Badgerys Creek Quarry and Brickworks Modification MP 10_0033 Modification 1 and MP 10_0014 Modification 3

Attachment A

Re: Exhibition of Modification Request for CSR Advanced Manufacturing Hub (MP 10_0014 MOD 3) – Badgerys Creek

Subject: Re: Exhibition of Modification Request (Modification 3) 235 Martin Road Badgerys Creek

Figure 3.16  
**Proposed Monier roof products manufacturing facility**

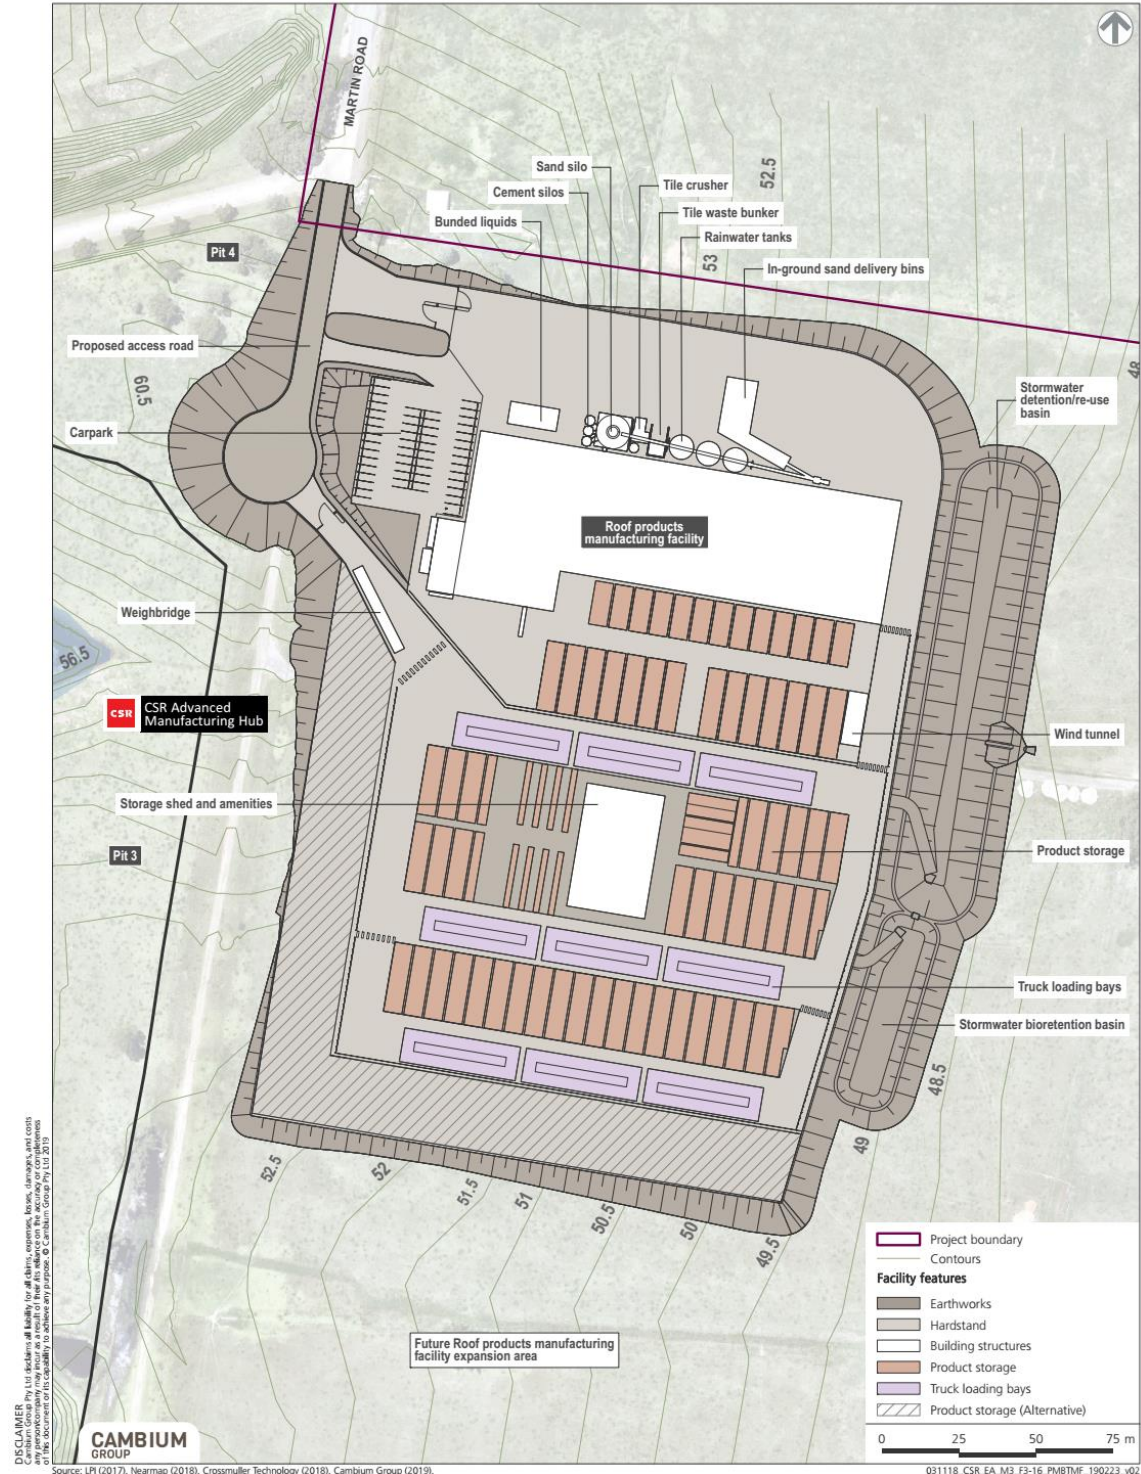
- 8 The site plans provided do not show the distance from the second airport runway to the expansion of the brick making facility, proposed roof manufacturing facility or NATA laboratory. A site context plan to scale should be provided showing the distance of the southern airport runway to the proposed site plan to confirm whether the proposed development is within the rectangular assessment trigger area as per page 6 of the guideline.

FIGURE 10A
 BADGERYS CREEK BRICK MAKING FACILITY, MODIFICATION 3
CONCEPT INTERSECTION LAYOUT AT
ELIZABETH DRIVE/MARTIN ROAD/MIRVAC ACCESS RD
WITH TRAFFIC SIGNAL CONTROL
 JOB NO.17179 25/02/19

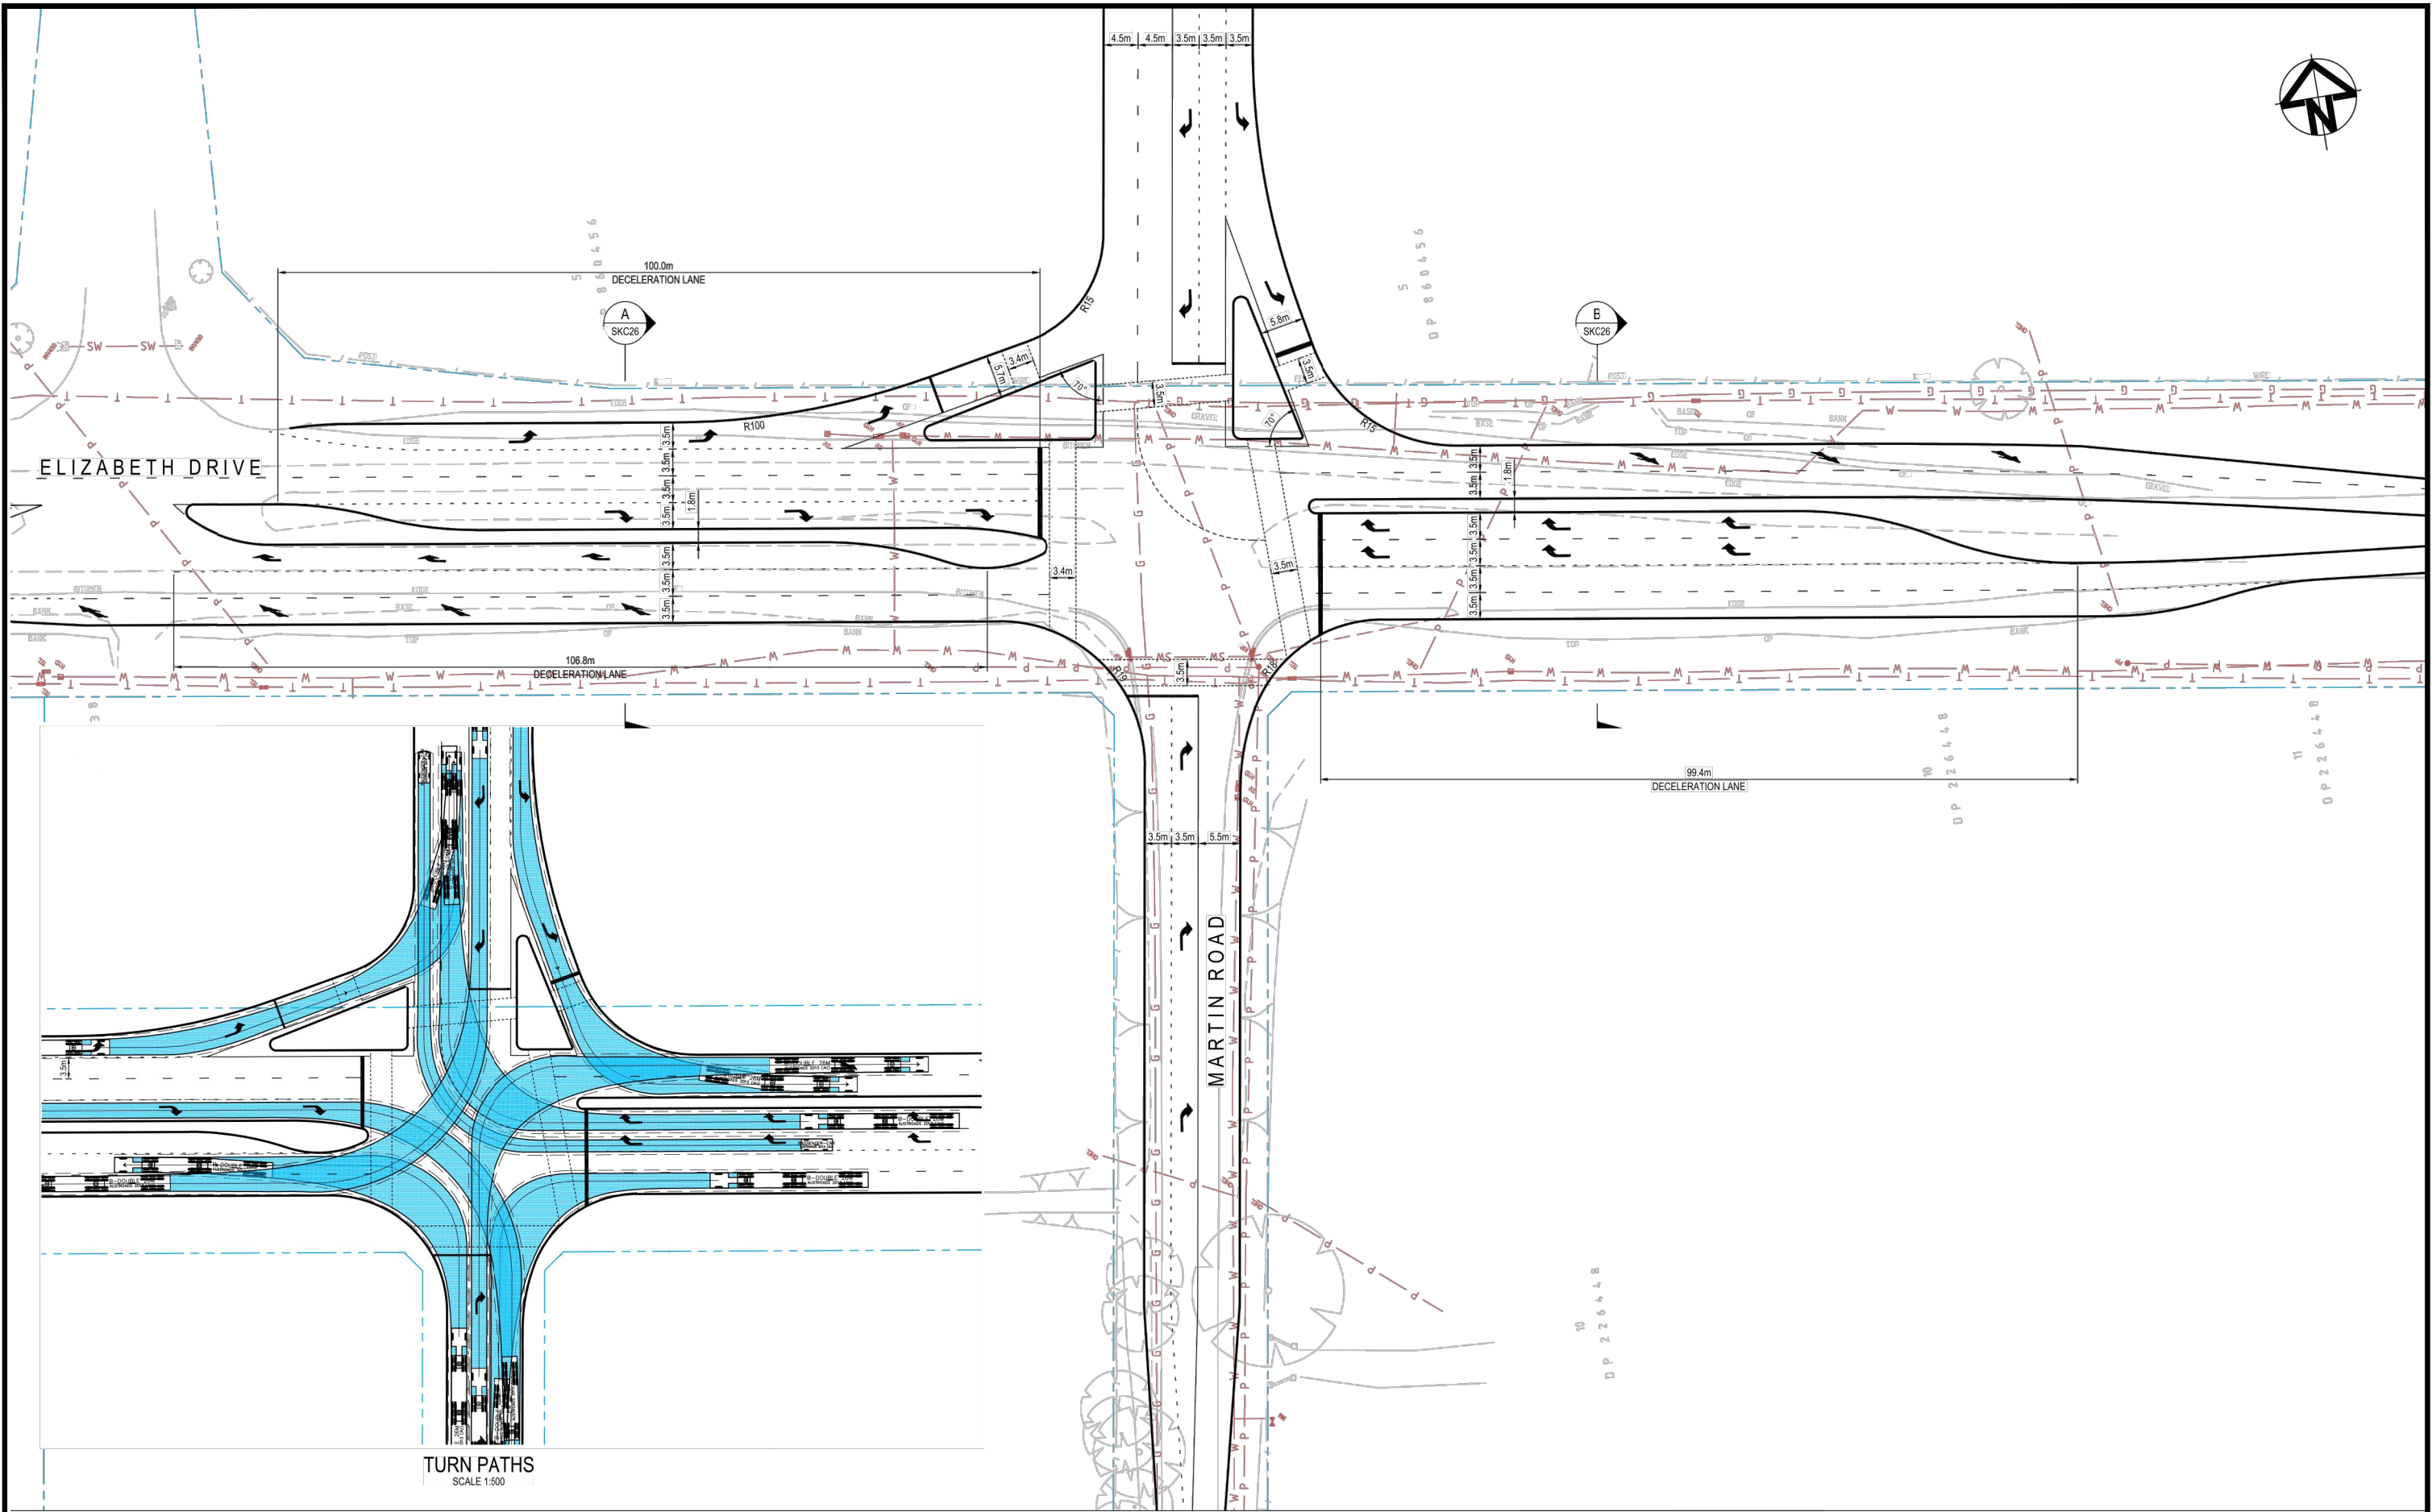
Modification 3 will result in an additional 544 truck movements per day Monday to Friday. This additional traffic will have significant impacts on the performance of the existing Elizabeth Drive/Martin Road intersection. Intersection performance analysis carried out by the applicant indicates that the intersection would be expected to operate with an unacceptable Level of Services E/F during AM and PM peak hours respectively.

As identified in the applicant's traffic report, these intersection performances will result in unsafe right turn vehicle movements and will require an intersection upgrade to traffic signals.

RMS "In principle" approval to the proposed traffic signals is required prior to the determination of MOD 3. The traffic signals should be fully operational prior to the operation.
